Recommendation Report for Planning Permission for Works or Extension to a Dwelling

REF NO: R/197/18/HH

LOCATION: 1 Pigeonhouse Lane  
Rustington  
BN16 2AY

PROPOSAL: Rear ground & first floor extension & front first floor gable extension.

Drawing Title: PROPOSED ELEVATIONS

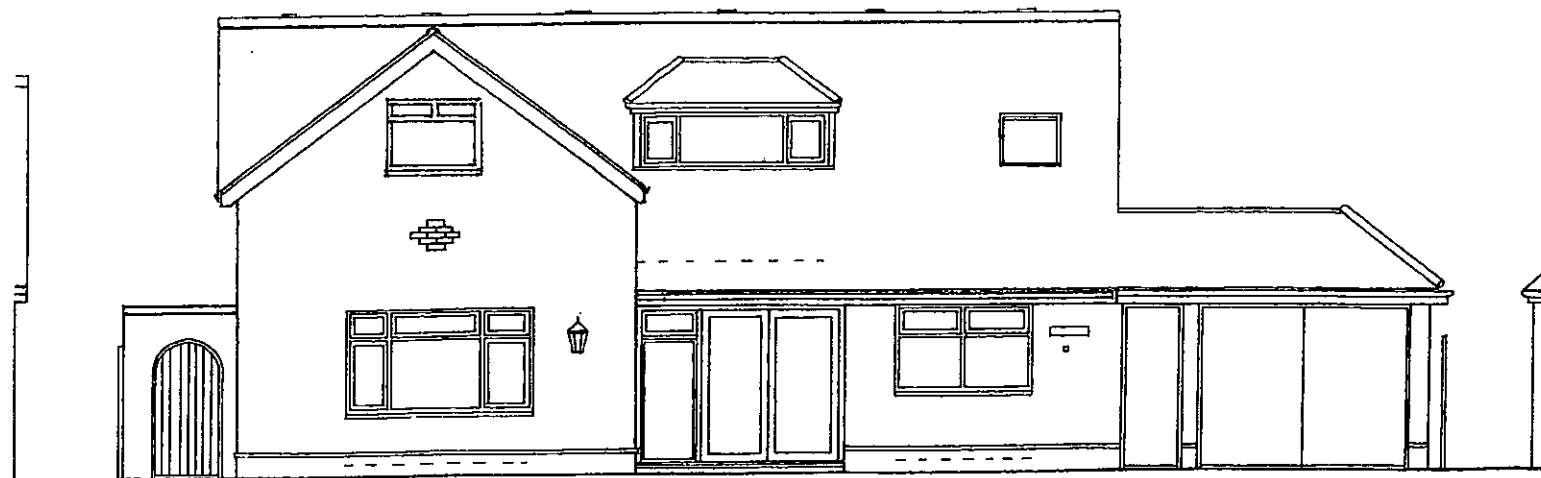
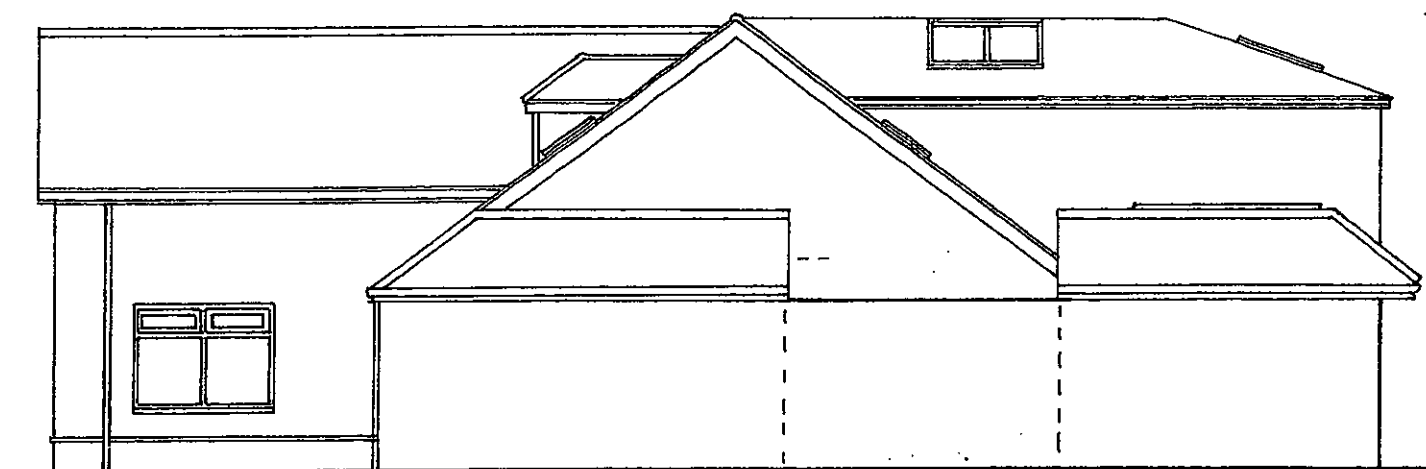
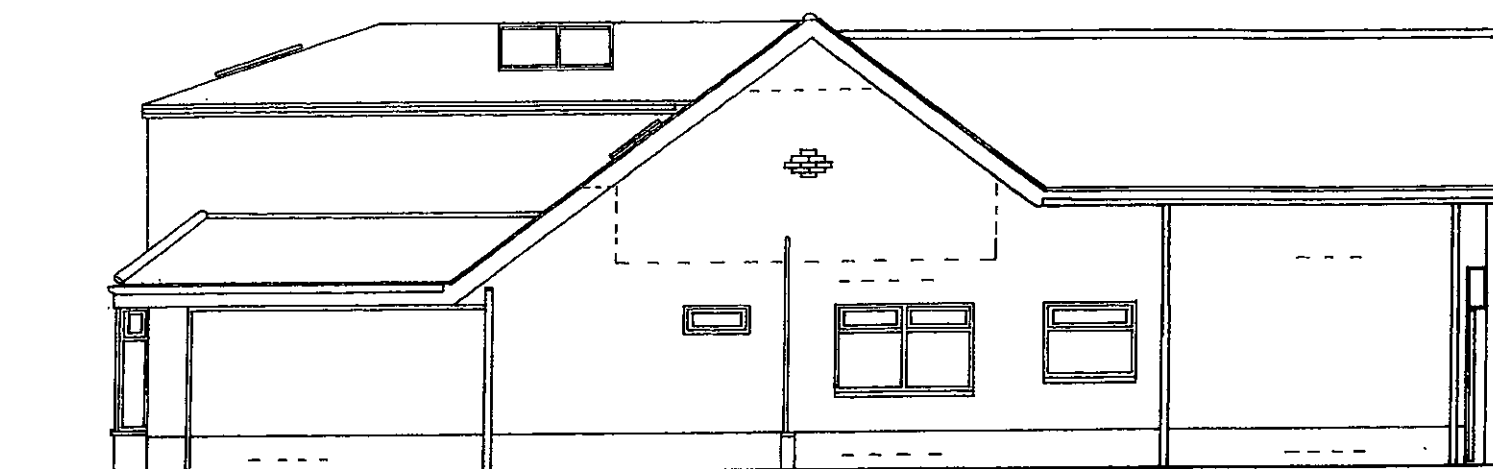
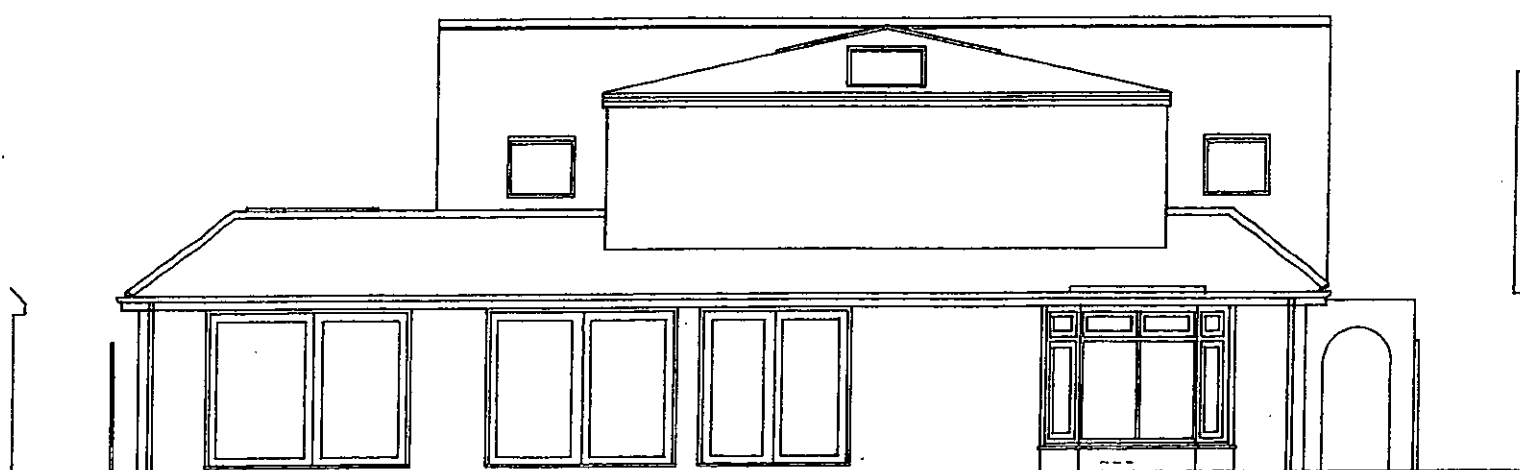
The front extension, by virtue of its siting, is visible from the street scene. The proposed extension would cause this Western projection to measure 9m deep, 5.6m wide and 5.8m high, and is therefore considered to be a significant addition to the host dwelling as a result of its massing and scale. The proposed extension meets the current Westernmost projection of the host dwelling, and extends no closer to the street scene, however, the proposal increases the maximum height of this projection by 1.2m, which gives the appearance of a new storey to the dwelling. With regard to its siting and scale, due to its design, the extension is only 0.2m lower than the ridge height of the host dwelling, which causes the proposal to have a detrimental impact on the visual amenity of the host dwelling, causing the entire Western elevation to appear as a prominent and obtrusive feature.

Due to the siting and design of the ground floor rear extension, it is considered to represent a subservient and sympathetic addition to the host dwelling. However, the proposed first floor rear extension extends 5.6m from the ridge of the host dwelling, past the line of the original dwelling, to reach the rear wall of the ground floor extension. This is not considered to be a sympathetic or subservient addition to the host dwelling, resultant of its significant scale, bulky, unattractive appearance, and the extension height meeting that of the host dwelling.

The proposed front extension extends 9m from the roof slope of the host dwelling, with the proposed rear extension extending 5.6m from this roof slope. This represents a total depth of property of 18m at first floor level. As a result of a separation distance to the neighbour to the North of 1.2m, this is considered to have a significantly detrimental overbearing impact on the occupiers to the dwelling to the North (#9 Cross Road). This overbearing is unacceptable, as it is unneighbourly, and will have an inappropriately

- 1 The proposed first floor extensions, by virtue of their scale, siting, size and proximity to the boundary will have an unacceptable overbearing impact upon the neighbouring property, 9 Cross Road, in conflict with policies D DM1 and D DM4 of the Arun Local Plan.

- 2 The proposed extensions, by virtue of their design, siting, massing and scale are considered to have an unacceptable incongruous impact upon the character and appearance of the host dwelling, and its locality, in conflict with D DM1 and D DM4 of the Arun Local Plan.

Drawing Title: PROPOSED FIRST FLOOR PLAN

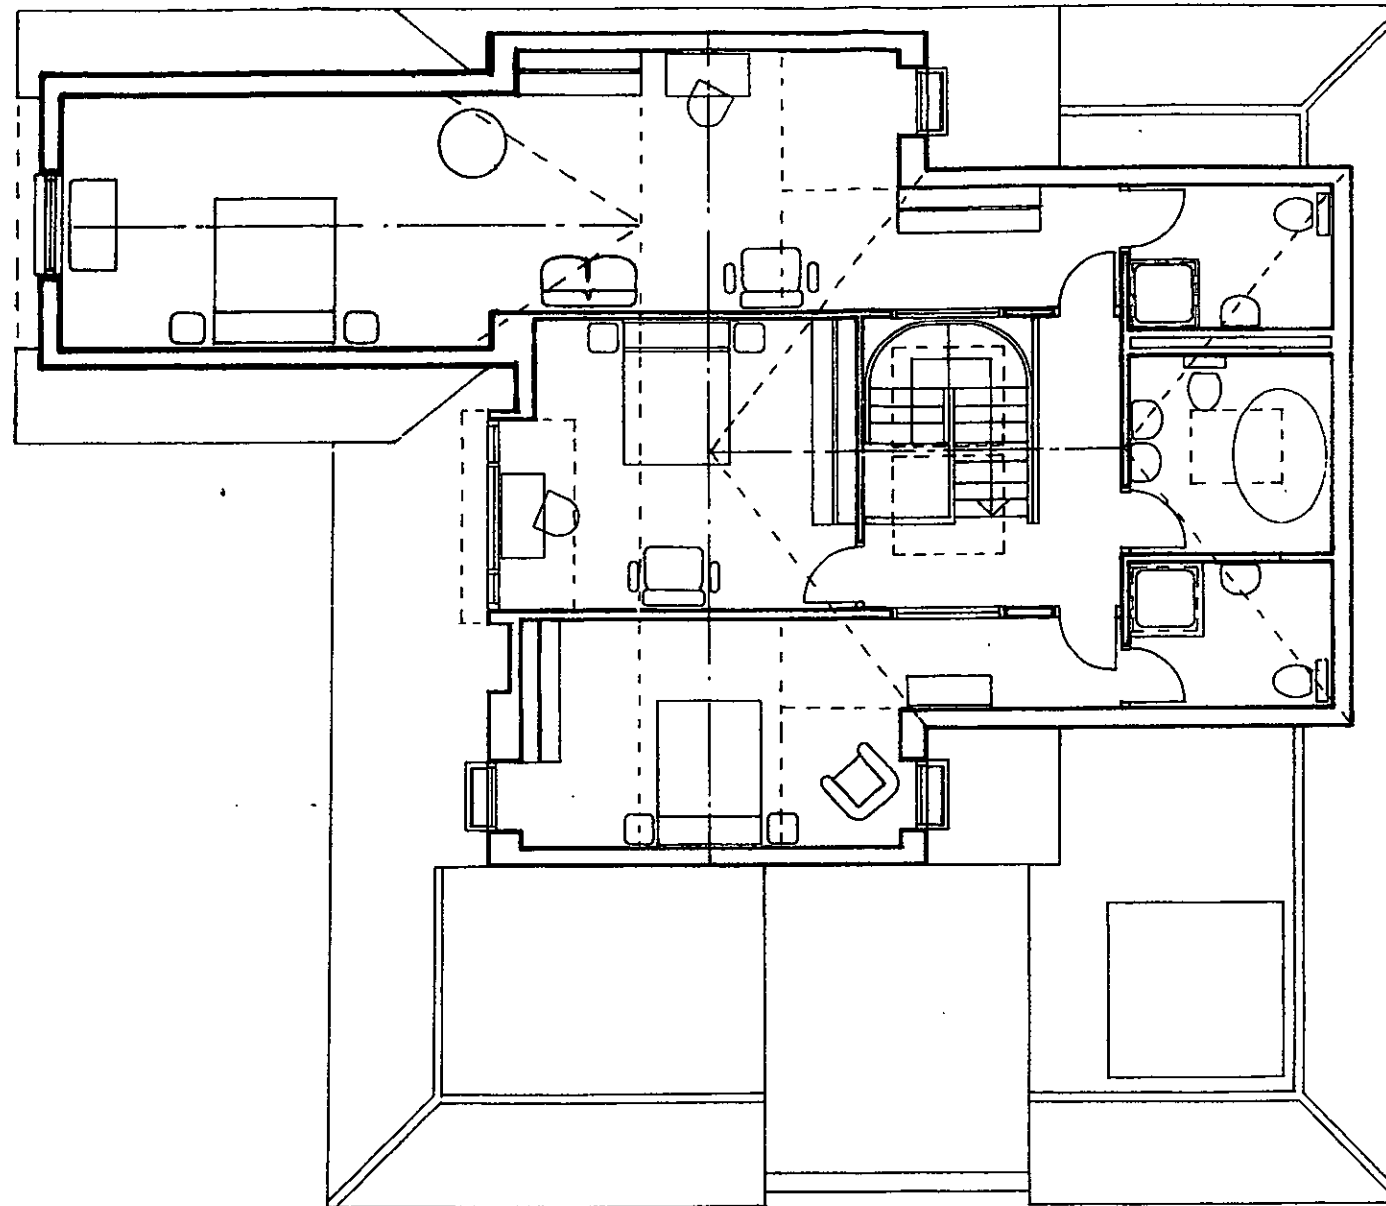
The proposed development is not considered to result in a loss of privacy to occupiers of adjacent dwellings. This is because the proposed additional windows are either at ground floor level, are rooflights, or face toward the street scene.
